RECOMMENDATION FOR PLANNING AND DEVELOPMENT COMMITTEE

APPLICATION REF: 3/2025/0194

PROPOSED CONVERSION OF GARAGE TO FORM ADDITIONAL LIVING SPACE, ADDITION OF WINDOW TO SIDE ELEVATION. THE FRONT ELEVATION WILL BE UNCHANGED. 27 POPLAR WAY, BARROW

EXISTING AND PROPOSED SITE PLAN.

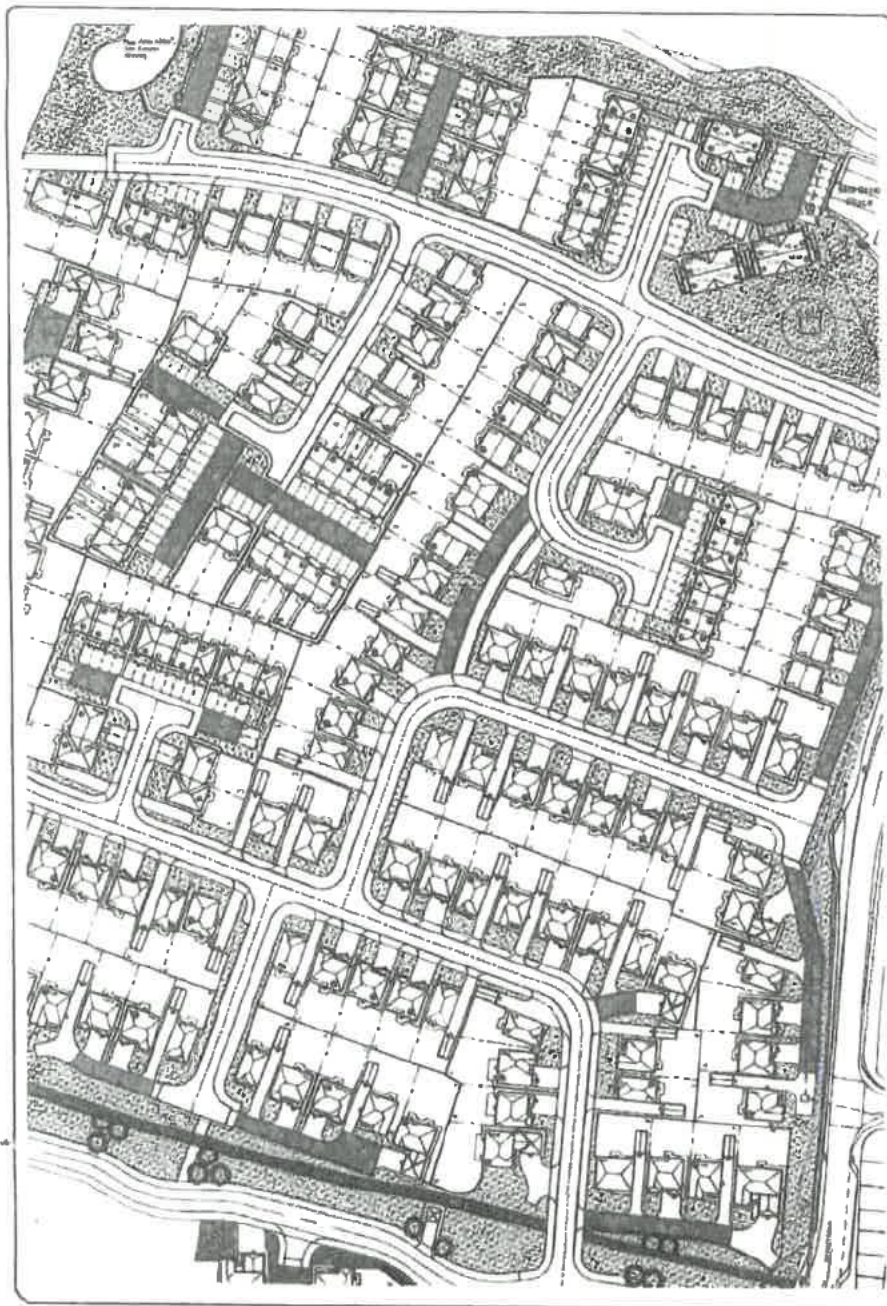
A consultation response from Lancashire County Council Highways was received on 13th May 2025 requesting 3no. on-site parking spaces be provided on a widened driveway due to the loss of the garage parking space.

5.5.1 A consultation response from Lancashire County Council Highways was received on 13th May requesting 3no. on-site parking spaces be provided on a widened driveway due to the loss of the garage parking space.

5.5.2 Following this, an amended plan has been received showing an addition parking space to the front of the application property measuring 2.4m by 4.8m. The proposal would therefore comply with parking standards for a four-bedroom property and is considered acceptable with respect to highway safety and parking.

GROUND FLOOR PLAN (PROPOSED)

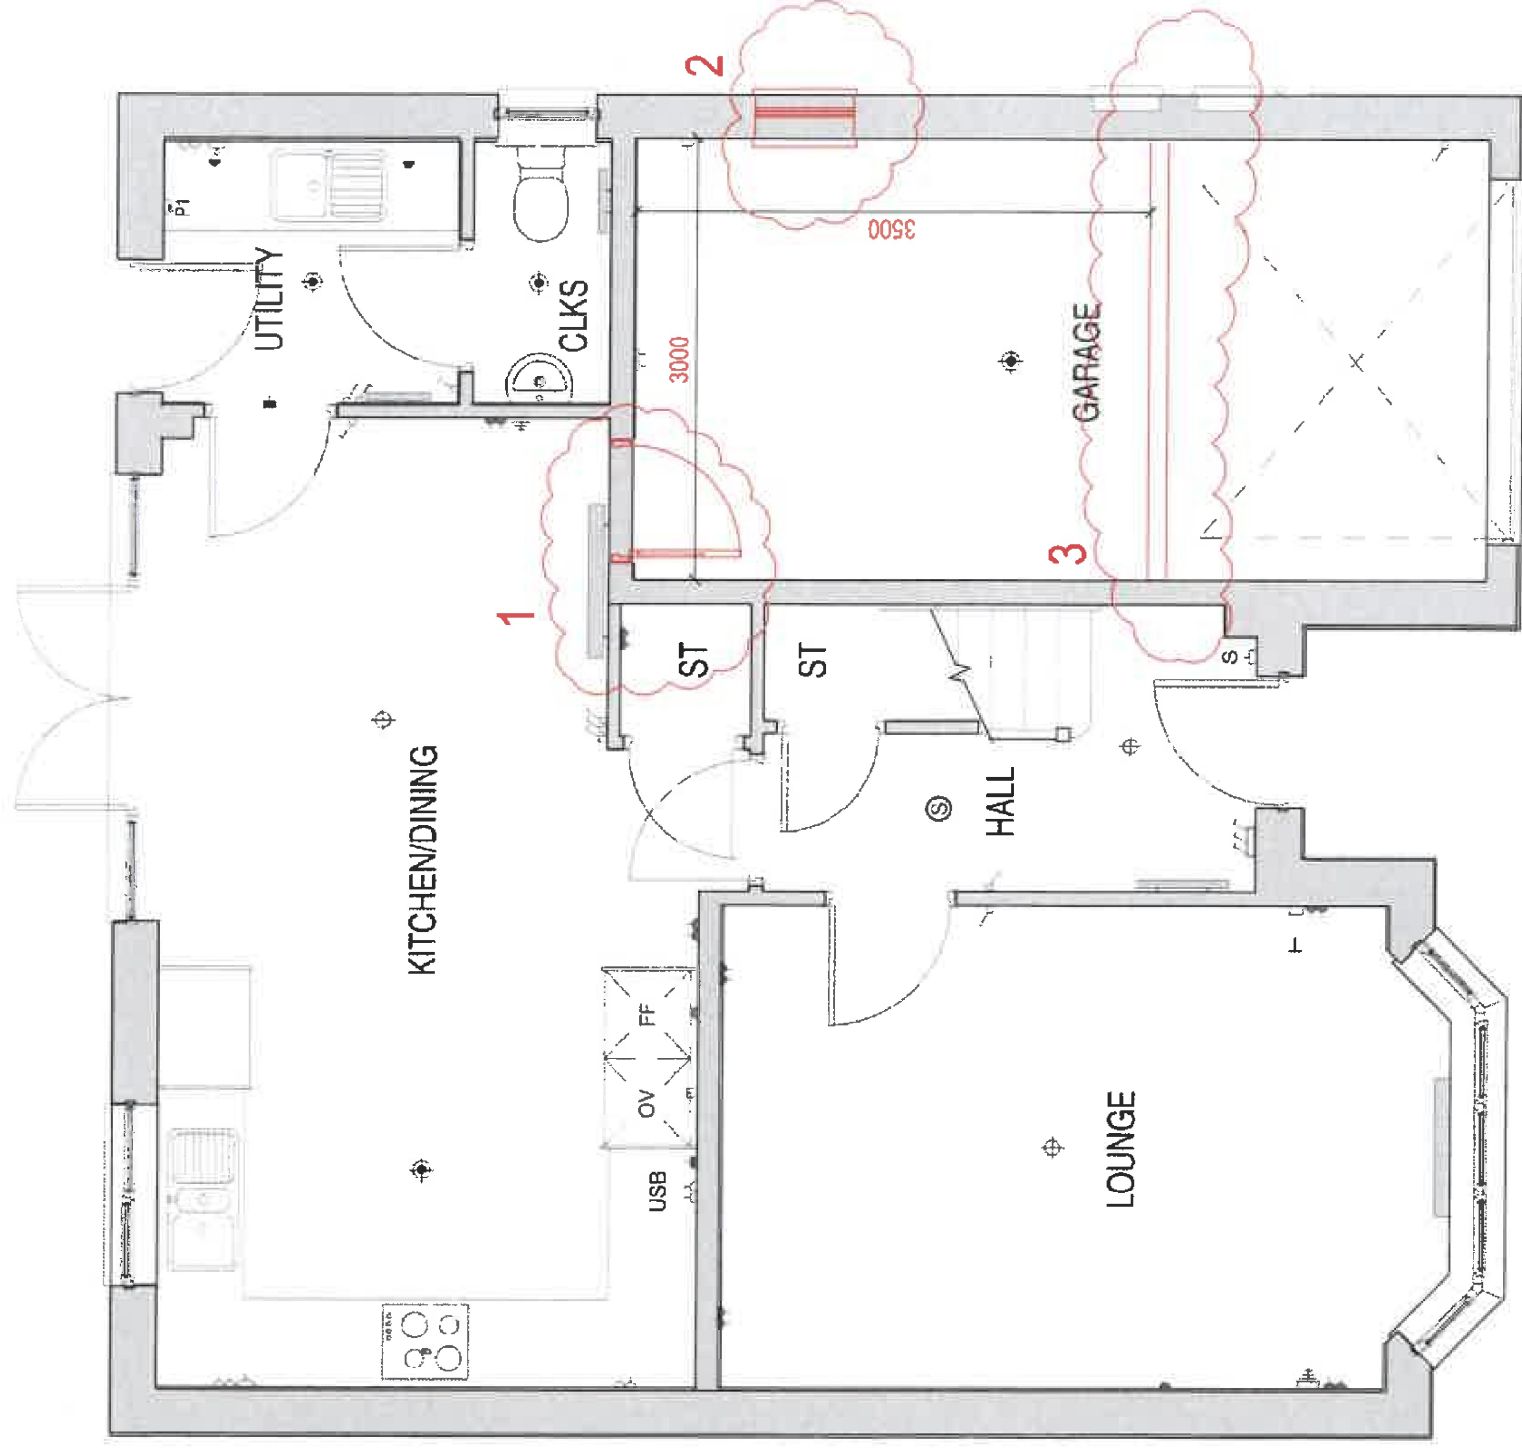
5.2.1 The proposed garage conversion would include the addition of 1no. ground floor window opening to the south-eastern gable elevation of the application property, facing towards the neighbouring dwellinghouse at no.29 Poplar Way. Despite this, no.29 Poplar Way does not benefit from any existing openings within its north-western gable elevation and therefore it is not anticipated that any undue impact by way of direct overlooking or loss of privacy would be resultant.
